11 February 2021
Ref 19090

ST LUKE'S GRAMMAR SCHOOL
PROPOSED SENIOR SCHOOL CAMPUS & SPORTS CENTRE (SSD-10291)
TRAFFIC & PARKING MATTERS
RESPONSE TO SUBMISSIONS

This *Response to Submissions* has been prepared in respect of traffic and parking matters raised by DoPIE, TfNSW and Northern Beaches Council raised in their submissions.

DRAWING TITLE
 STAGE 2 DROP-OFF & PICK-UP AREA
 B99 VEHICLE & TOYOTA COASTER
 ADDRESS
 No.800 Pittwater Road,
 Dee Why

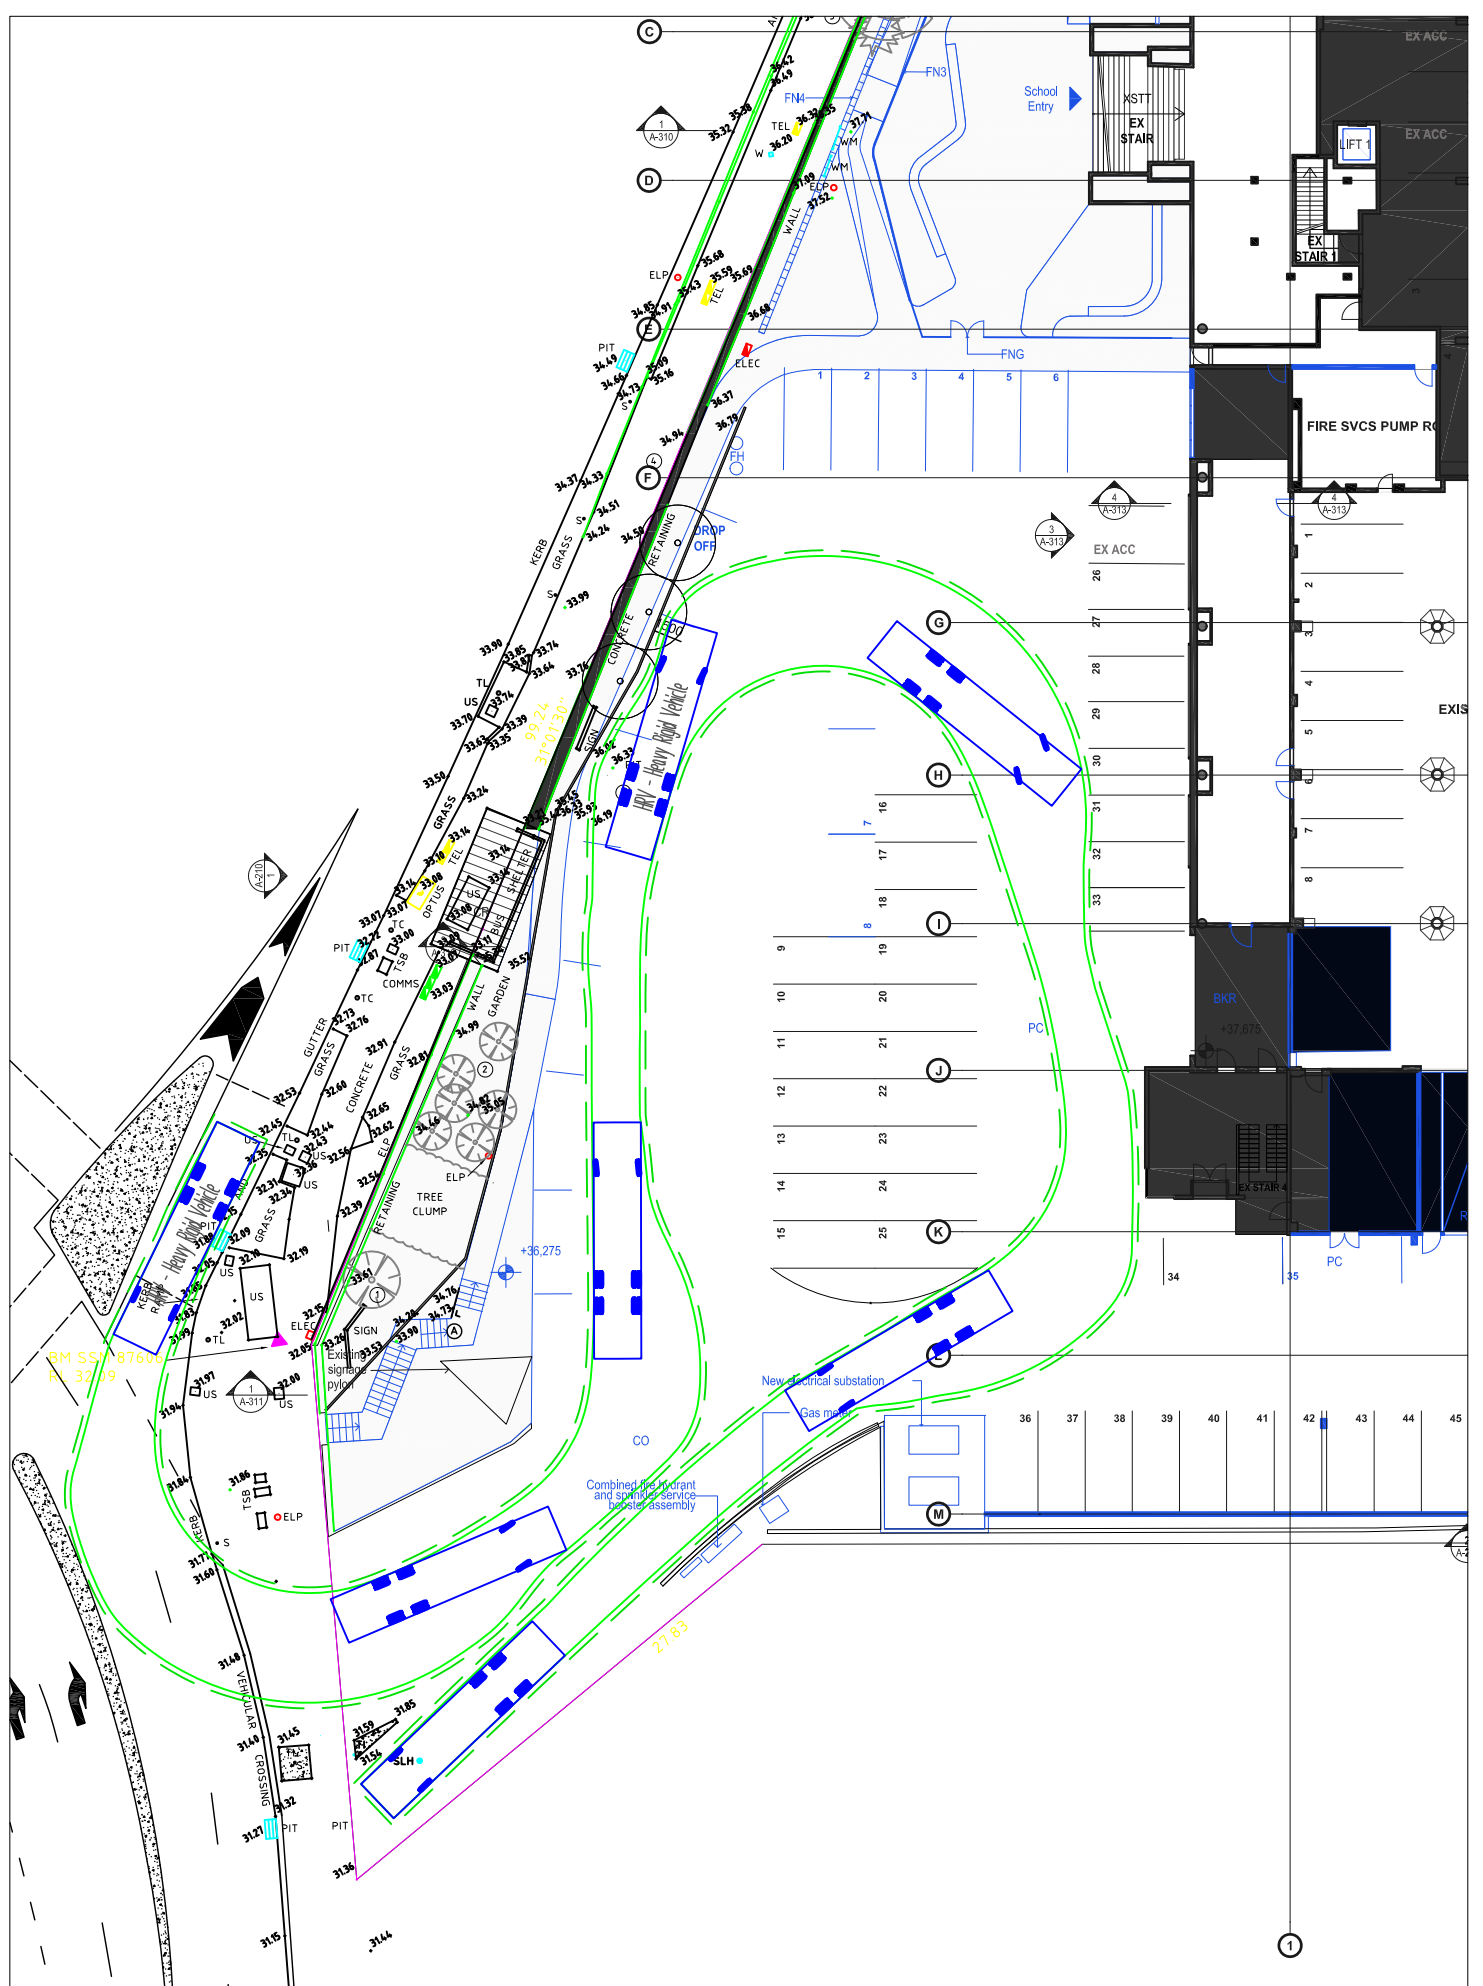
The layout of the drop-off/pick-up bay proposed on the *Senior School* site in Stage 2 is illustrated on Figure 12 and makes provision for the following:

- a projected peak drop-off/pick-up demand of 1.6 cars and 1.4 cars respectively (rounded-up to 2 cars), shown in red
- a spare capacity of a further 5 cars in the drop-off/pick-up bay, shown in green
- an overflow capacity of a further 4 cars on the driveway which can be accommodated *without* disrupting other traffic flows in or out of the site, shown in yellow
- the capacity to accommodate a total of 11 cars without disrupting other traffic flows in/out of the site

By way of comparison, the drop-off/pick-up bay proposed on the *Senior School* site in Stage 2 will have the *same capacity* as the school’s existing indented bay in Tango Avenue, but will cater for *less than one-third the number of students*, whilst noting also that those *Senior School* students will generate substantially less traffic activity than both the *Middle School* and *Junior School* students.
